DECISION DELEGATED TO DEVELOPMENT MANAGER

Application No:	H09-0801-20	Applicant:	Mr D & A Rulewski
Proposal:	Erection of four detached two-storey dwellings, two detached garages and demolition of existing bungalow		
Location:	47 Low Lane Holbeach Spalding		
Terminal Date:	3rd March 2021

PLOT 1 NORTH ELEVATION

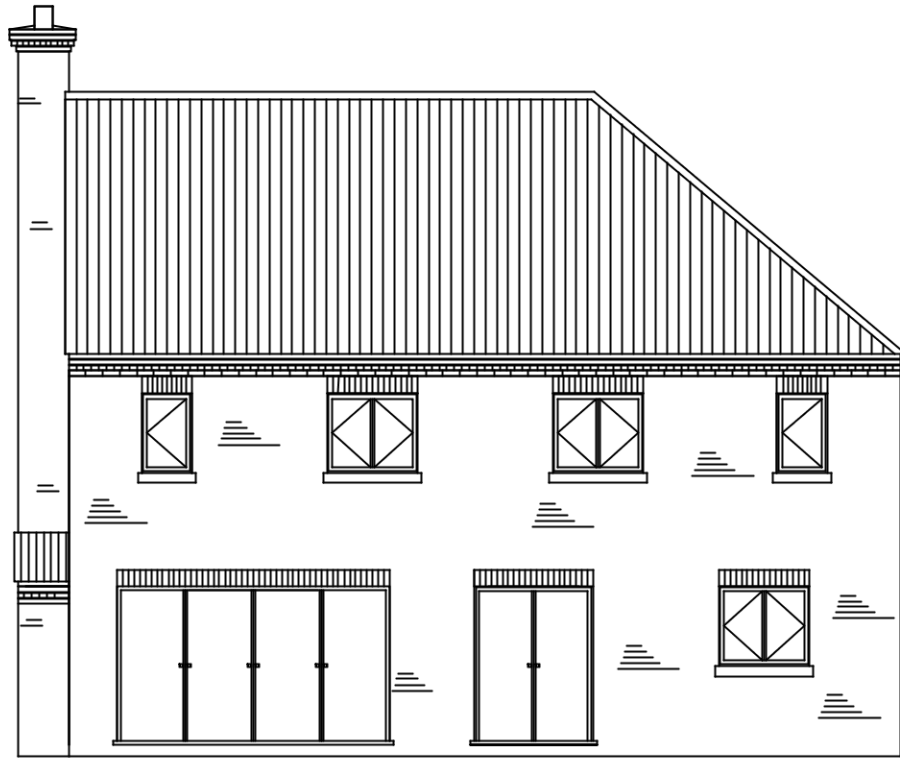
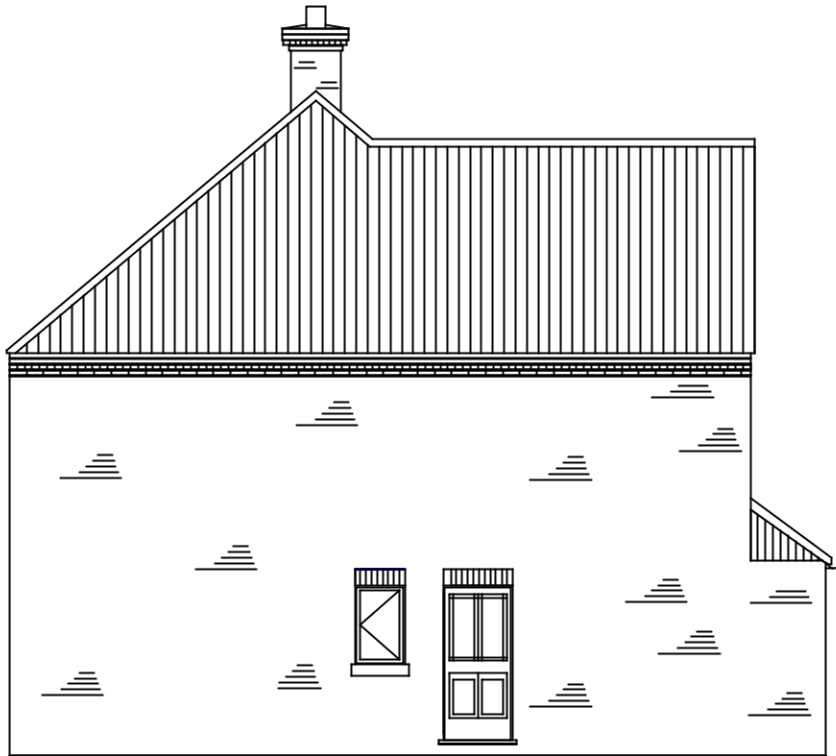
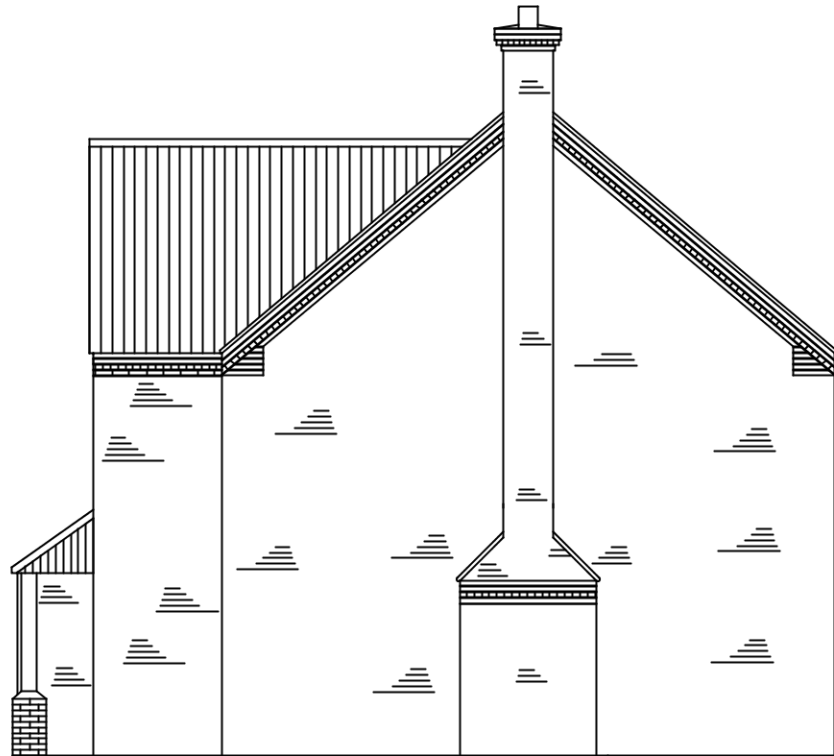
In this regard, the main concern of the scheme has been the relationship between the existing property known as the Chestnuts and the nearest plot (Plot 1).

Most of the footprint of the house in Plot 1 would extend beyond the rear wall of the Chestnuts. The apex height was formerly 9.75 metres and some overbearing effect could have been caused onto the residents of the adjoining property when enjoying the rear garden. One of the residents expanded on this issue in their objection statement. It was the case officer's opinion that

Firstly, revised plans were requested and subsequently submitted with a reduction of the pitch degree that reduces the apex height from 9.75 to 9 metres with no further depth.

After reviewing the planning history of the Chestnuts, no first-floor rear bedroom is close to Plot 1. The new house was set back roughly 2.30 metres from the boundary fence with the Chestnuts. Therefore, the occupiers of the Chestnuts would have enjoyed daylight from the habitable rooms and no unacceptable overshadowing would have occurred by reason of the development. In any case, daylight assessment was undertaken and subsequently submitted to the Local Planning Authority. It was considered acceptable to demonstrate that no overshadowing effect would have occurred.

However, concerns about overbearing impact remained by the objector and Plot 1 and 2 were exchanged after negotiating with the applicant. In doing so, the two-storey bulk of the dwellinghouse would be set back further from the boundary with the Chestnuts and the nearest structure would be single-storey detached garage which is far less harmful. As a result of that, any probability of overbearing impact would be clearly dissipated.

NOTES:

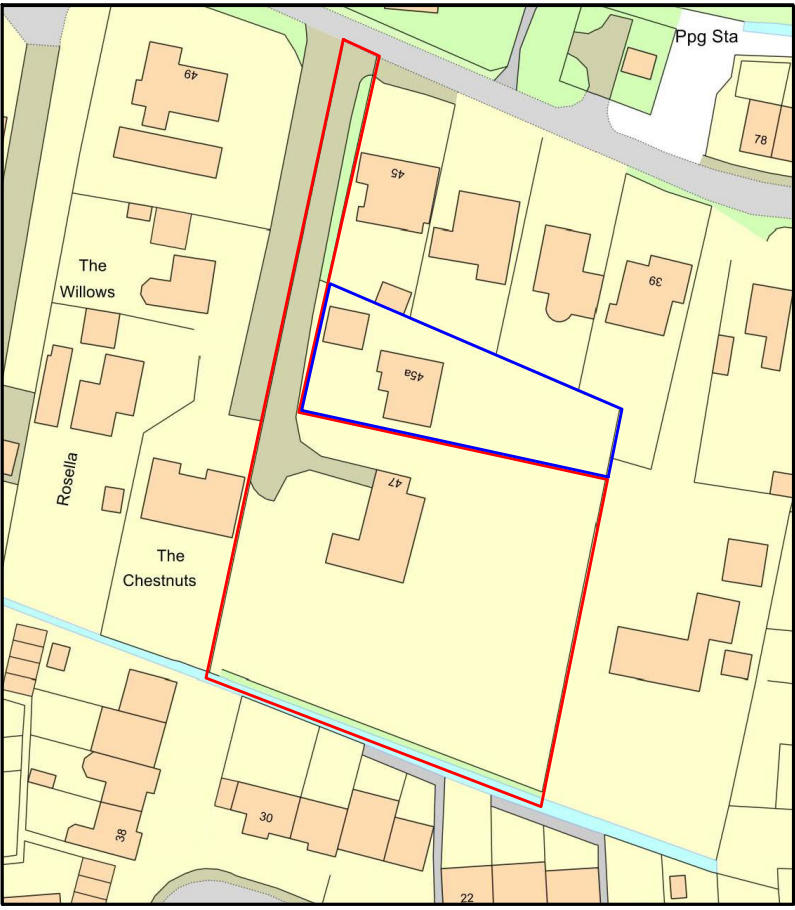
- Finished ground floor levels shall be raised at 3.5m AOD.
- Flood resilient construction shall be incorporated in the buildings to a height 300mm above ground floor level.
- Safe refuge would be provided at first floor level and future occupiers would be provided with an

-Surface water run-off from the roofs of the proposed dwellings and detached garage should be discharged into soakaway crates. The infiltration system together with associated drainage should be designed to BRE Digest 365 and meet the requirements of Part H of Building Regulation.
